DRAWING REVIEW COMMENT ANSWERS

3.11.24

SHEET TCL 2.22.24

Sheet: TCL

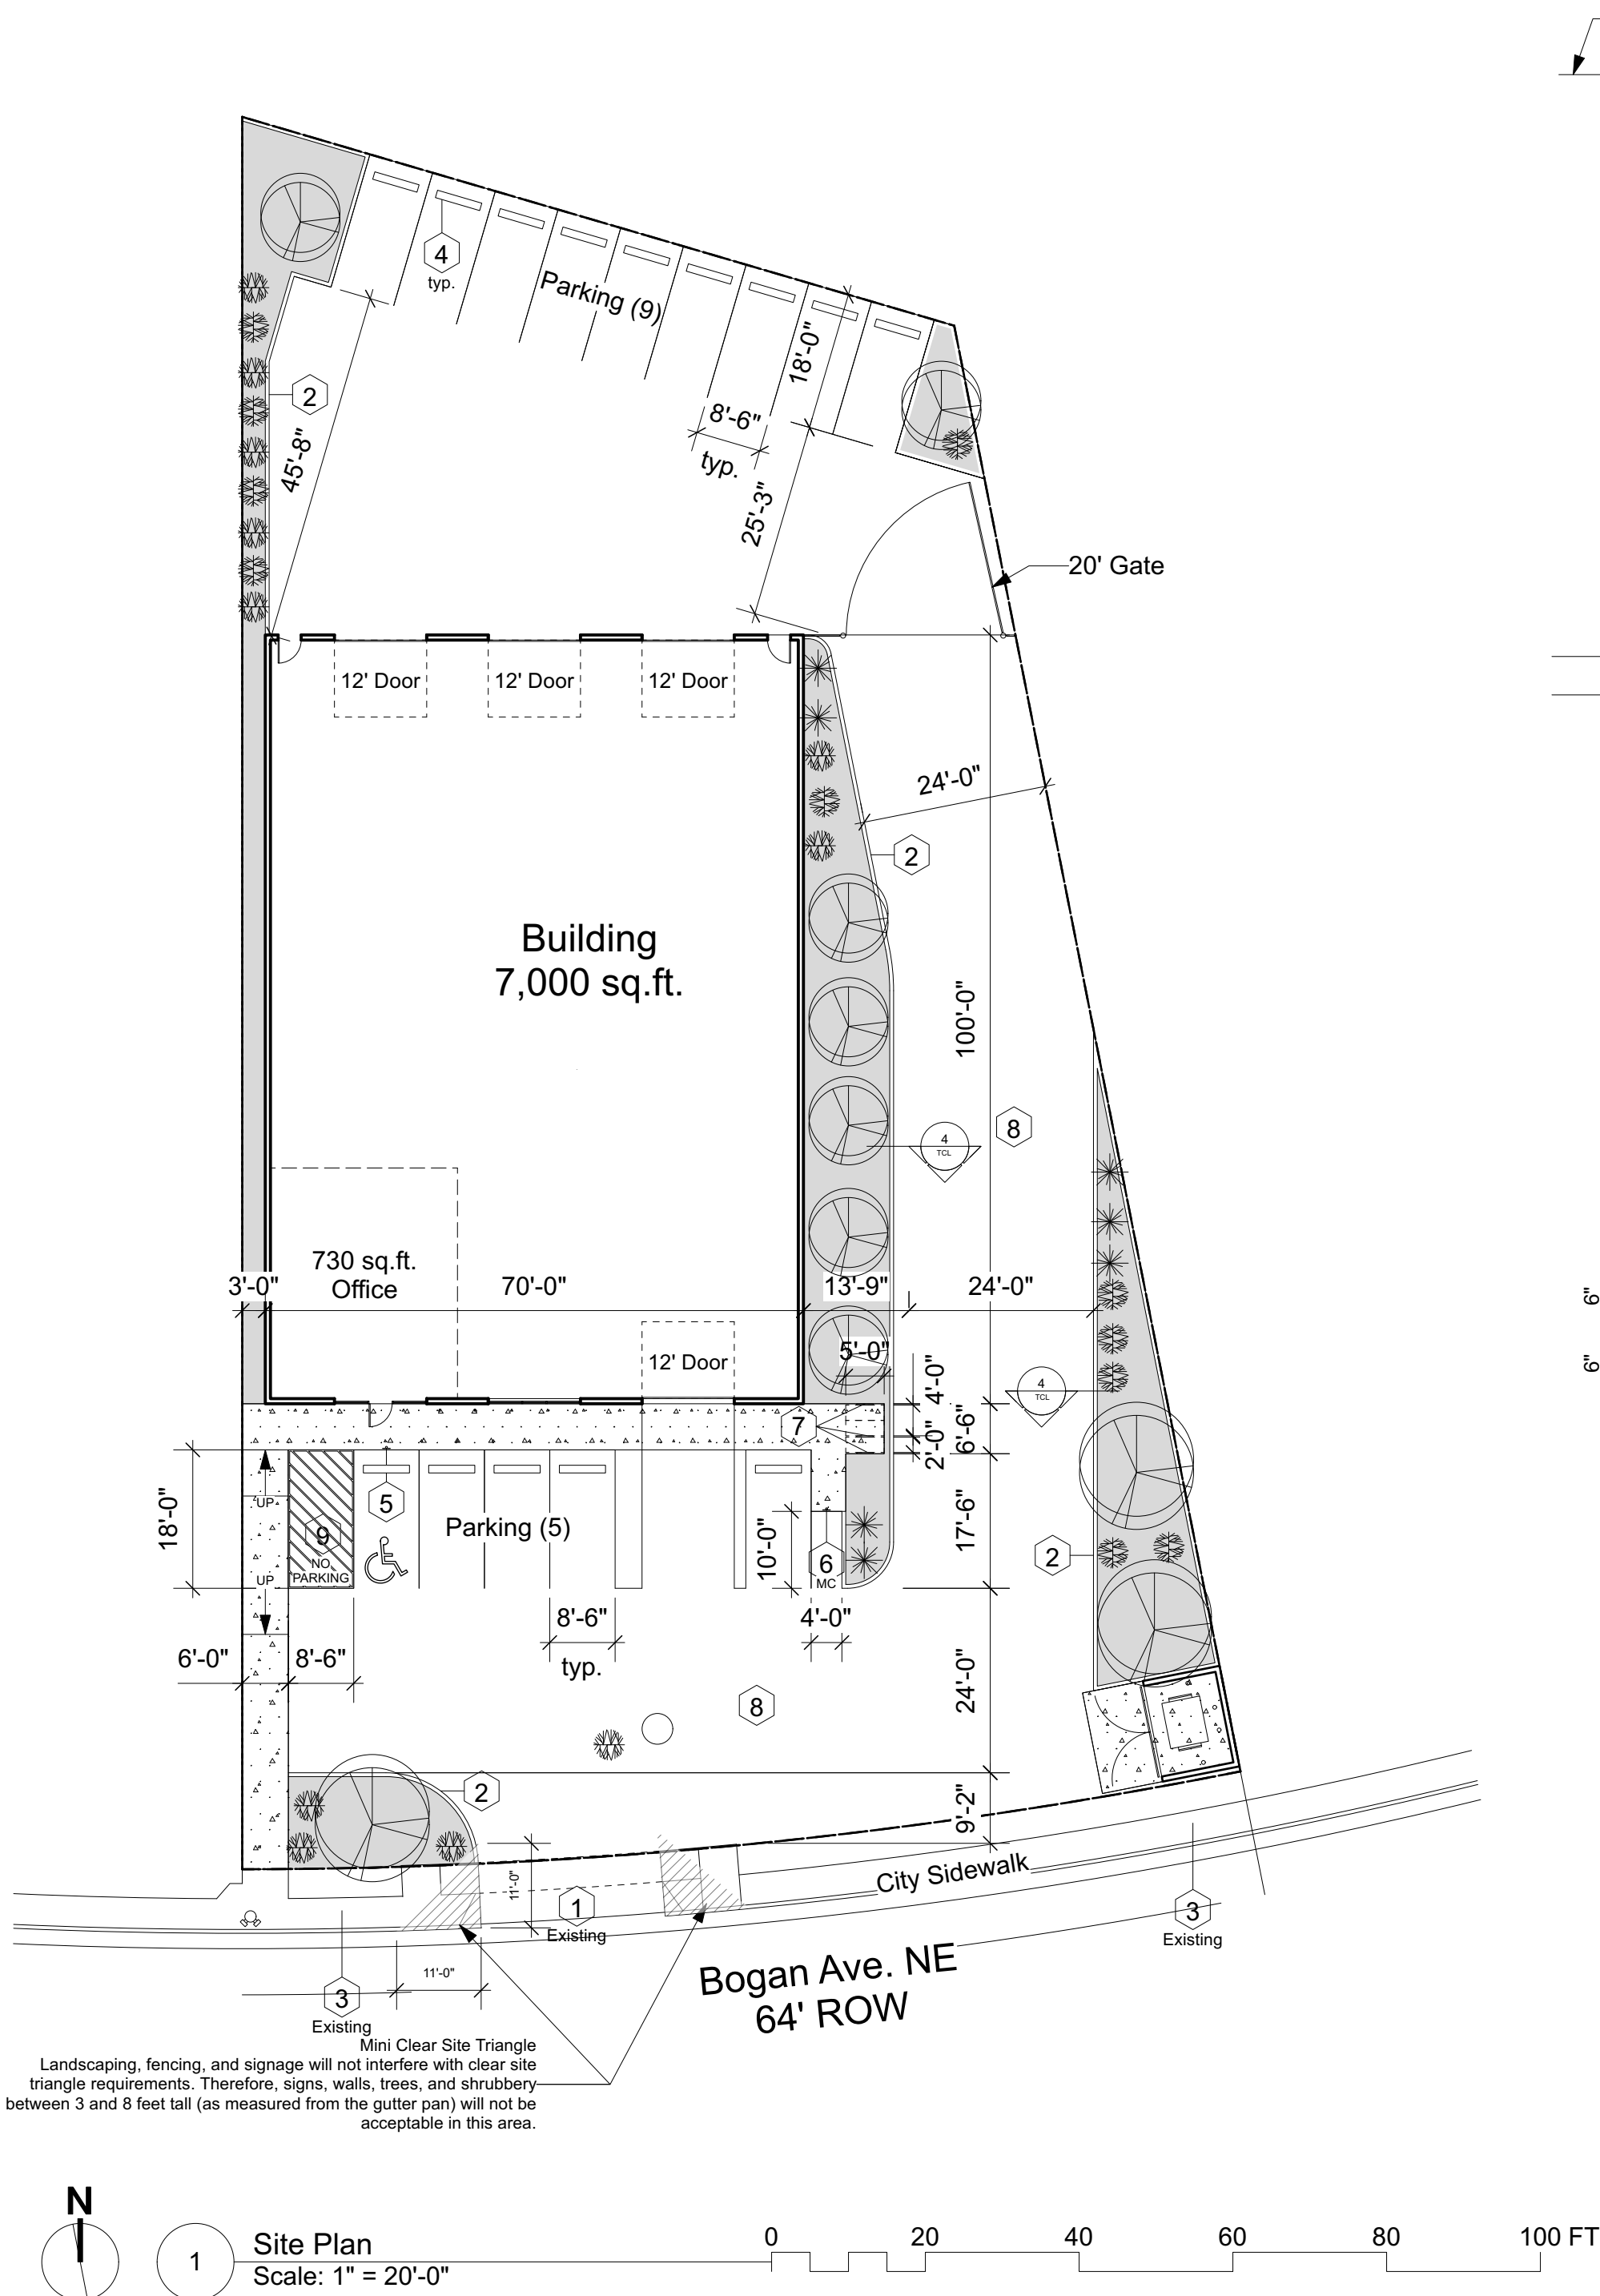
1. The address on the DTIS is 3901 Bogan Ave NE, but that address appears to be a developed lot for Windsor Door Sales. I think this TCL is for the vacant lot to the west, which I am coming up with an address for 3938 Bogan Ave NE; UPC 101706109417830904. Please confirm.
3808 is what the real estate broker has?

4. It appears the bike racks may interfere with the pedestrian use of the sidewalk in this area. Possibly pour some concrete east of this location (in landscape area) and put them there?
Relocated

5. Keyed Note 9: Please add the color blue for the diagonal striping. Some Contractors will stripe it white.
Added
6. Provide an It appears there is enough room between the existing sidewalk and the P/L.
Added

7. Since the drive entrance appears to be wider than 24 ft. Place detectable warning surfaces in the new sidewalk mentioned in #4 above.
Added
8. Provide a 6' wide accessible path from the ROW. It appears the proposed sidewalk along the western edge of the property doesn't connect with the City sidewalk.
Corrected- it connects.

9. Since Keyed Note 8, may allow for gravel (ABC), provide asphalt or concrete paving in the accessible parking space and aisle.
Removed the other surface note in keyed note 8, only asphalt or concrete will be used

10. Please revise/delete Keyed Note 11. The small amount of work in the ROW will not require a Work Order. For your reference, I have attached a memo that provides the specific conditions when a Work Order is required. When improvements in the ROW do not meet the thresholds outlined in the memo, the improvements are permitted through Municipal Development Construction Services Division.
Removed

11. Keyed Note 13. Since you will be providing an accessible route across the entrance, you don't have to replace the "wings" or ramps in the existing drive entrance.
Revised fo ada path across driveway entrance.

5 Bike Rack Detail  
Scale: 3/4" = 1'-0"

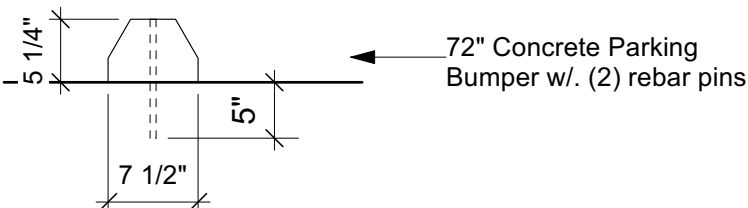
2. The minimum number of bicycle spaces per the IDO is 3, rather than 2. Please revise.
Corrected
3. In the bike rack detail. Provide 4' between racks, so each bike gets 2'.
Corrected
